Mark Brown - RE: MP 08_0046 - d'Albora Marina, The Spit - Preferred Project Report

From: "Ian Tait" <Ian.Tait@maritime.nsw.gov.au>
To: "Mark Brown" <Mark.Brown@planning.nsw.gov.au>
Date: 17/10/2011 10:55 AM
Subject: RE: MP 08_0046 - d'Albora Marina, The Spit - Preferred Project Report

Figure 6: Plan illustrating proposed amendments to marina (indicated in orange) and land based works including new hardstand area and modified car parking (Source: Proponent's PPR)

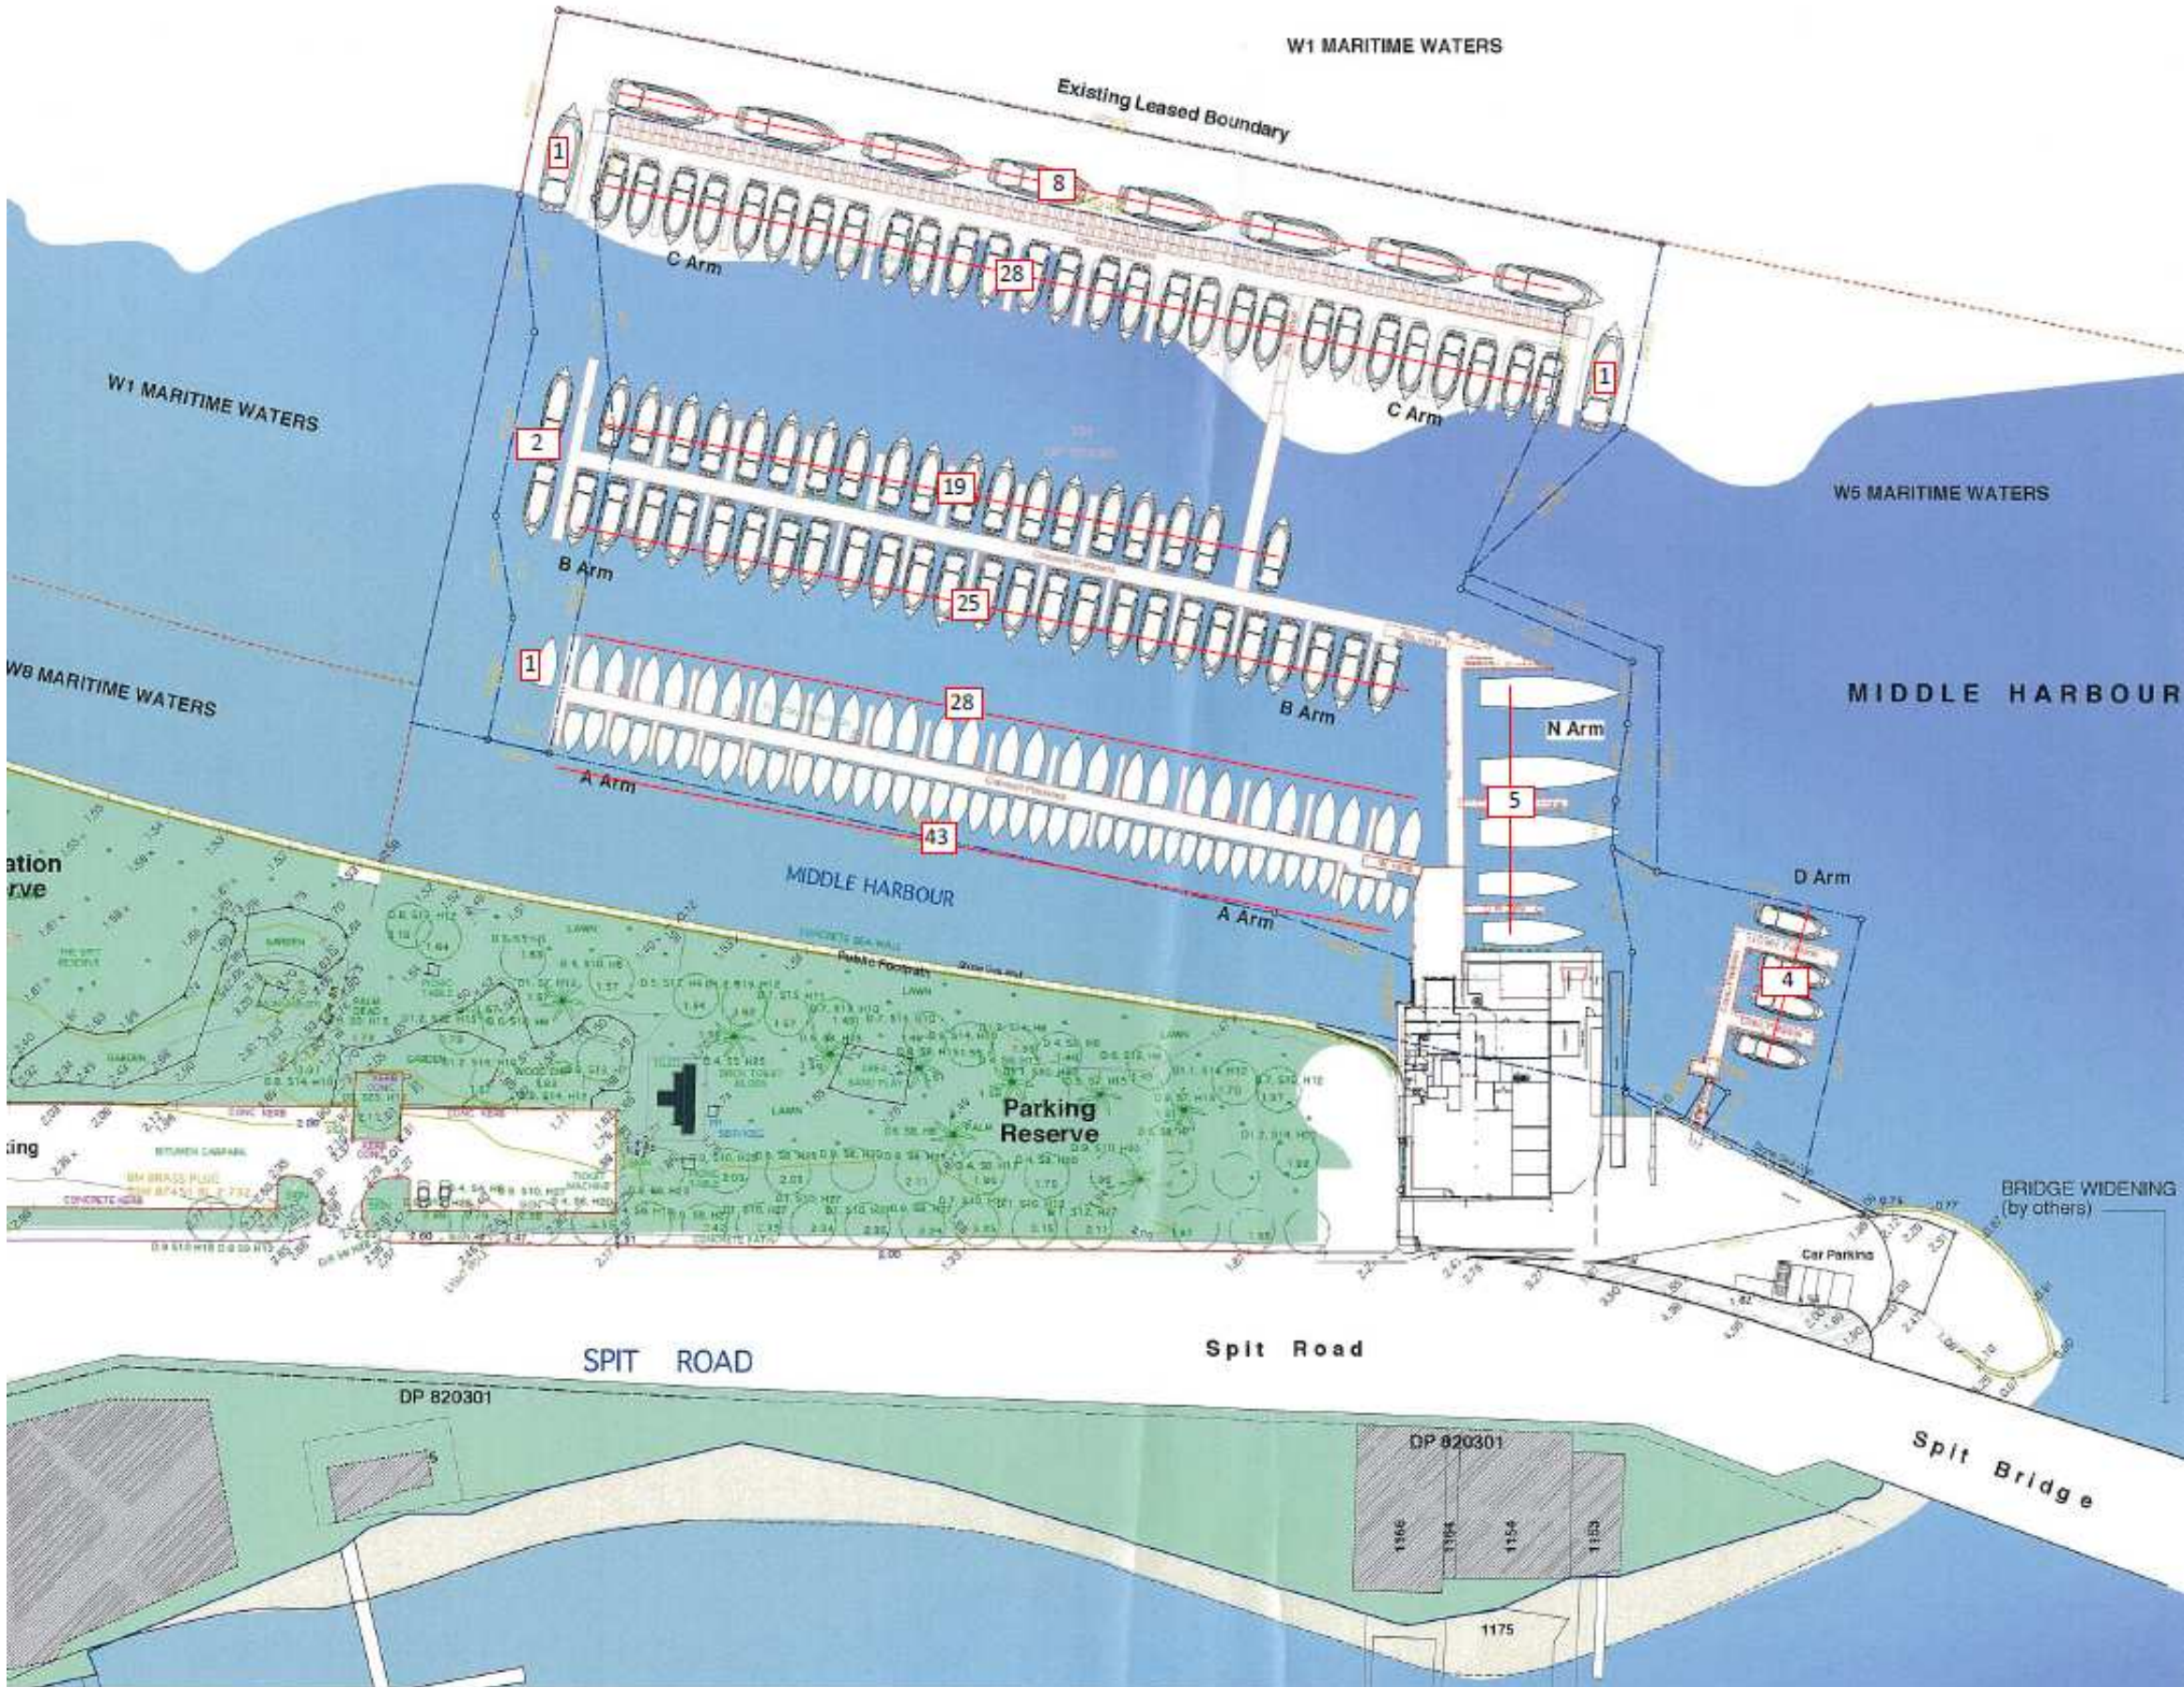
Comparing the proposed marina with the existing structures reveals that some piles will be removed. All piles and piers to be removed are to be completely withdrawn from the bed of the Bay and not cut off.

The first sentence in Item 7 was incorrect in NSW Maritime's submission and should have read:
 There appears to be insufficient fairway width at the entrance to Arm B inner and Arm A outer.
